Transport Assessment

Moorebank Intermodal Precinct West – Stage 3 (SSD 10431)
(Response to Submissions)

Ref: P1277r02v1
28/07/2020

Following submission of the original MPW Stage 3 submission, including the transport assessment dated 24 April 2020 (ref: P1277r01v2), a number of comments were received from TfNSW. A response to these matters is provided below.

Figure 5: Network Traffic Volumes, with MPW S2 - Scenario 2

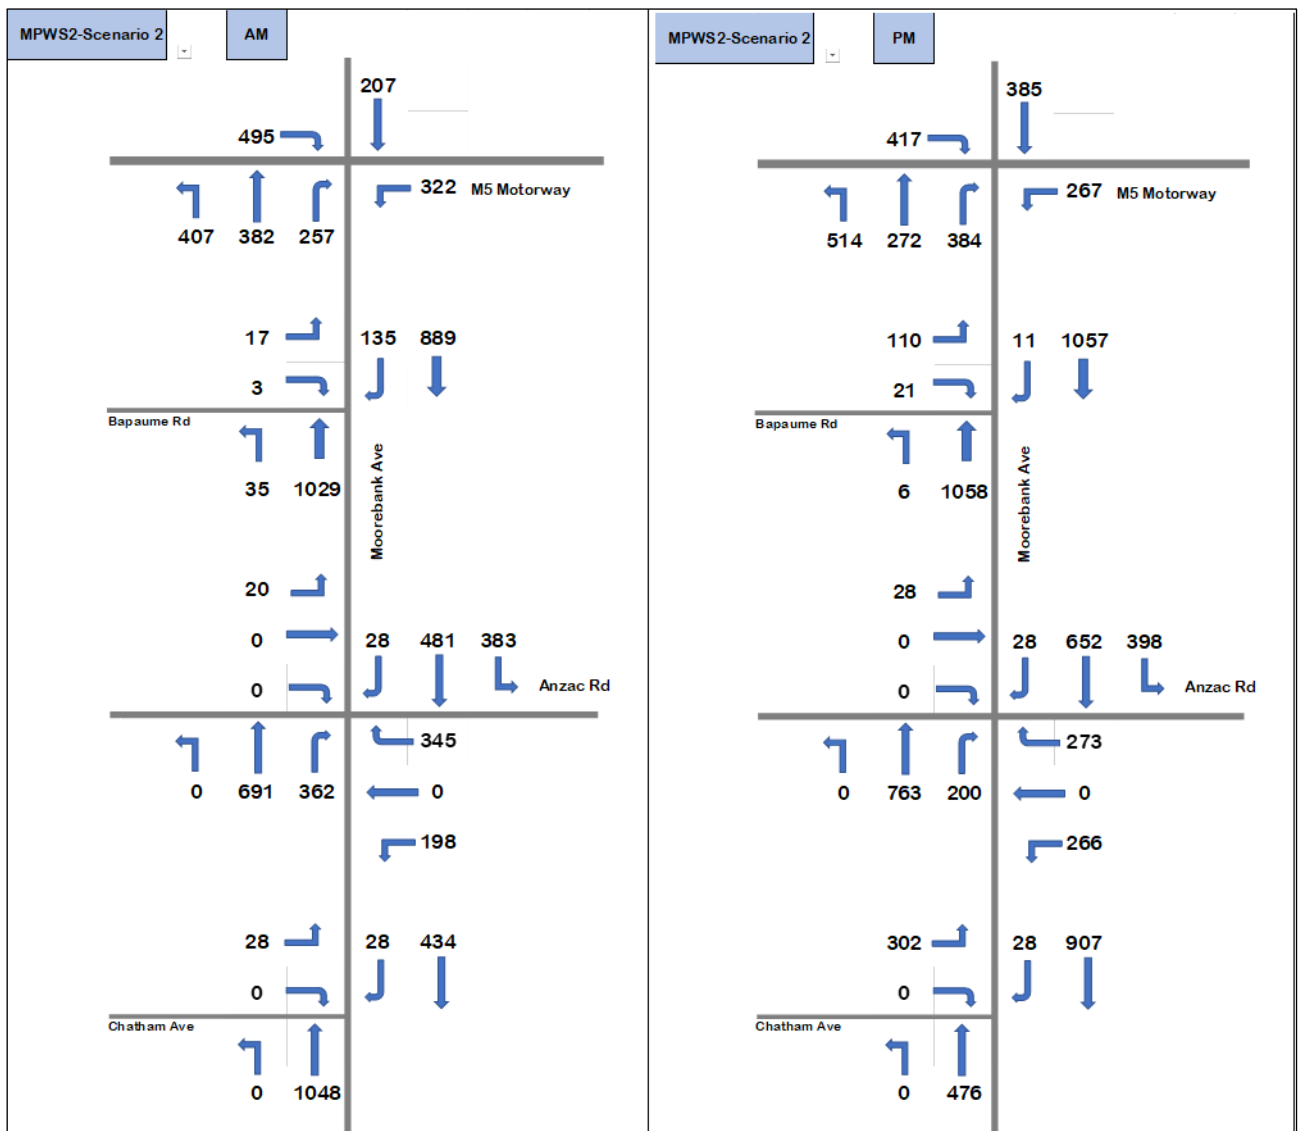
TfNSW Comments	Ason Group Response
<p>Network Traffic Volumes, with MPW S2 - Scenario 2</p> <p><u>Comment</u></p> <p>It is noted that Figure 5 of the Transport Assessment prepared to support the development application states that the traffic volumes included in Figure 5 are based on the Moorebank Precinct West (MPW) Stage 2 Proposal - Construction Traffic Impact Assessment, dated October 2016 (2016 MPW Report).</p> <p>It advised that:</p> <ul style="list-style-type: none"> Based on the traffic distribution adopted for Stage 2-Scenario 2 in Figure 5 of the Transport Assessment, number of construction vehicle movements included in Figure 5 are lower during the morning peak period and higher during the afternoon peak period compared to the construction traffic movements reported in the 2016 MPW Report; and Morning and afternoon traffic movements for Stage 2-Scenario 2 included in Figure 5 are not the same as traffic movements included in 2016 MPW Report for this scenario. <p><u>Recommendation</u></p> <p>It is requested that the applicant clarifies the apparent inconsistencies between the Transport Assessment Report and the Moorebank Precinct West (MPW) Stage 2 Proposal - Construction Traffic Impact Assessment, dated October 2016</p>	<p>TfNSW (and other submissions) are referencing an earlier 2016 CTIA report, whereas the submitted report relies on the later 2017 Response to Submissions CTIA report volumes—see below.</p> <div data-bbox="900 775 1358 1417"> </div> <p>For clarity, the figures adopted came from Figure A-5 and A-6 of that report by Arcadis.</p>

Figure 6: Construction Access Route Comparison

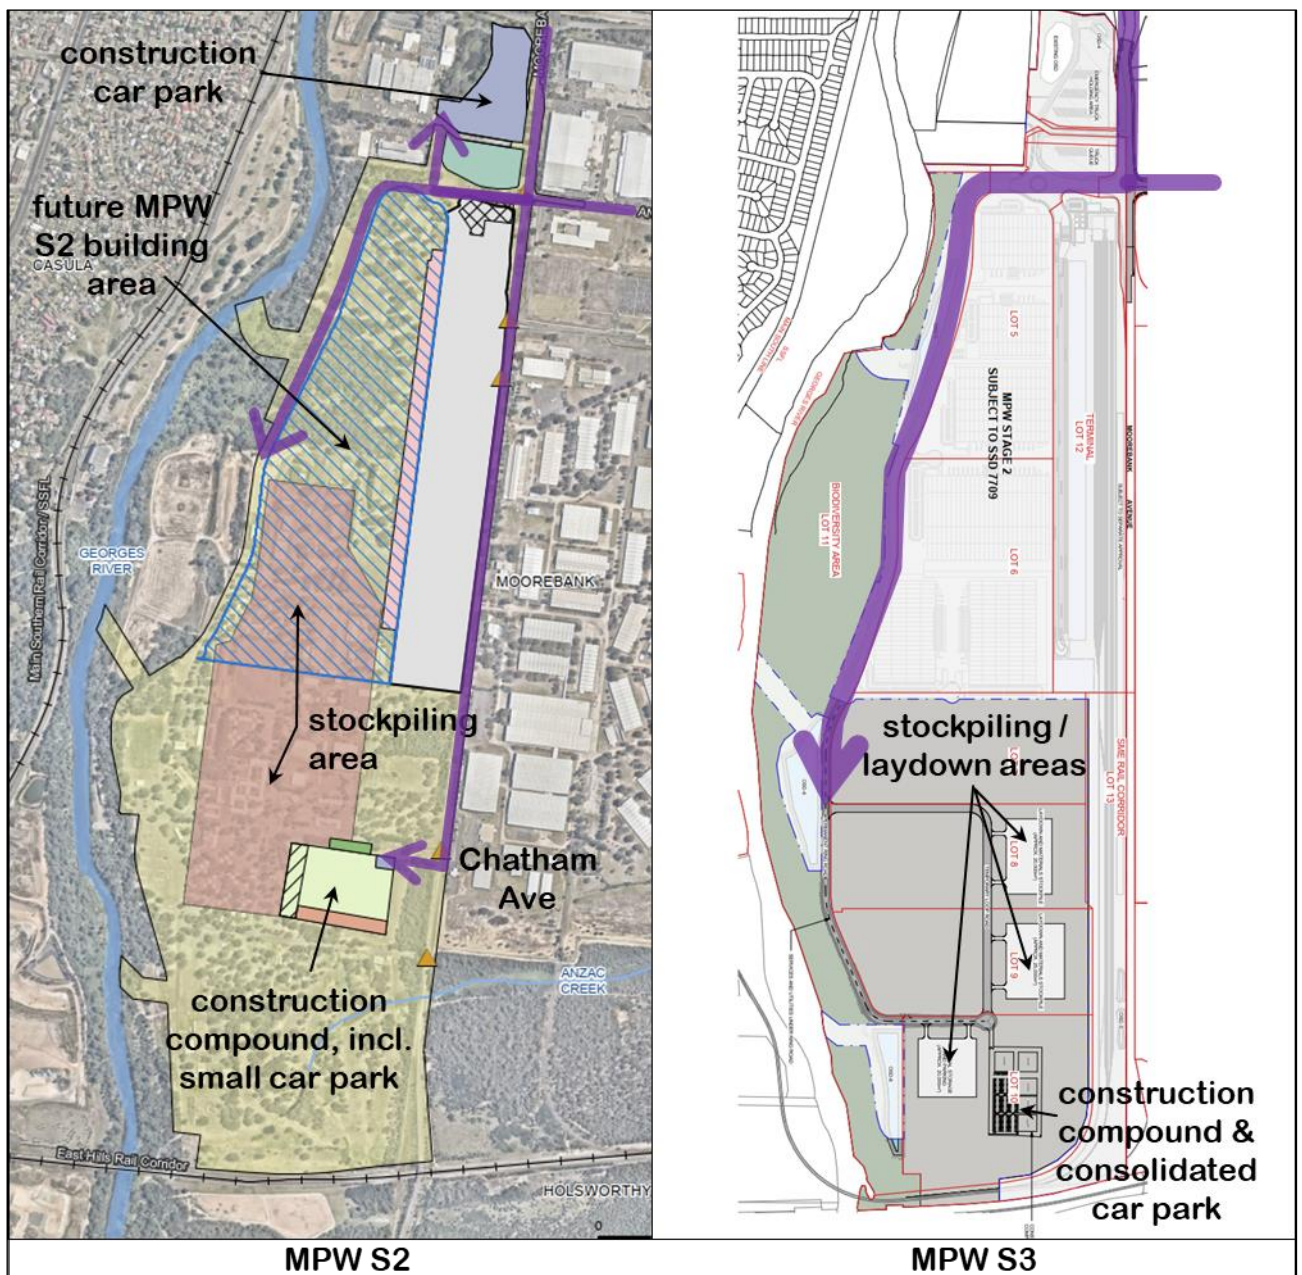
TfNSW Comments	Ason Group Response
<p>Impacts on the Moorebank Avenue/Anzac Road Intersection</p> <p><u>Comment</u></p> <p>It is noted that Section 3.2 of the Transport Assessment states the following:</p> <p><i>“Removal of the Chatham Avenue site access for MPW construction site access during later stages of MPW construction (Works Period C through to completion)”</i></p> <p>It is also noted that Section 3.3 of the Transport Assessment states the following:</p> <p><i>“The proposed changes will not have a material impact off-site, with all construction traffic still traversing the MPW precinct access at Anzac Road, noting that there are specific controls in place to restrict construction vehicles from using Moorebank Avenue to the south. There is expected to be some localised redistribution of construction vehicle movements,”</i></p> <p>It is advised that the redistribution of traffic as a result of the closure of Chatham Avenue access would have the potential to impact on the operation of the Moorebank Avenue/Anzac Road intersection.</p> <p><u>Recommendation</u></p> <p>It is requested that the applicant undertakes traffic modelling as part of the applicant's Response to Submissions to confirm that the proposed removal of Chatham Avenue access would not have a material impact on the operation of the Moorebank Avenue/Anzac Road intersection.</p>	<p>As discussed in Section 1.3 of this report, the Chatham Avenue access is to be retained throughout construction of MPW Stage 3.</p> <p>As such, the proposal is now effectively unchanged from that of the approved MPW Stage 2 and additional traffic modelling is not required.</p>
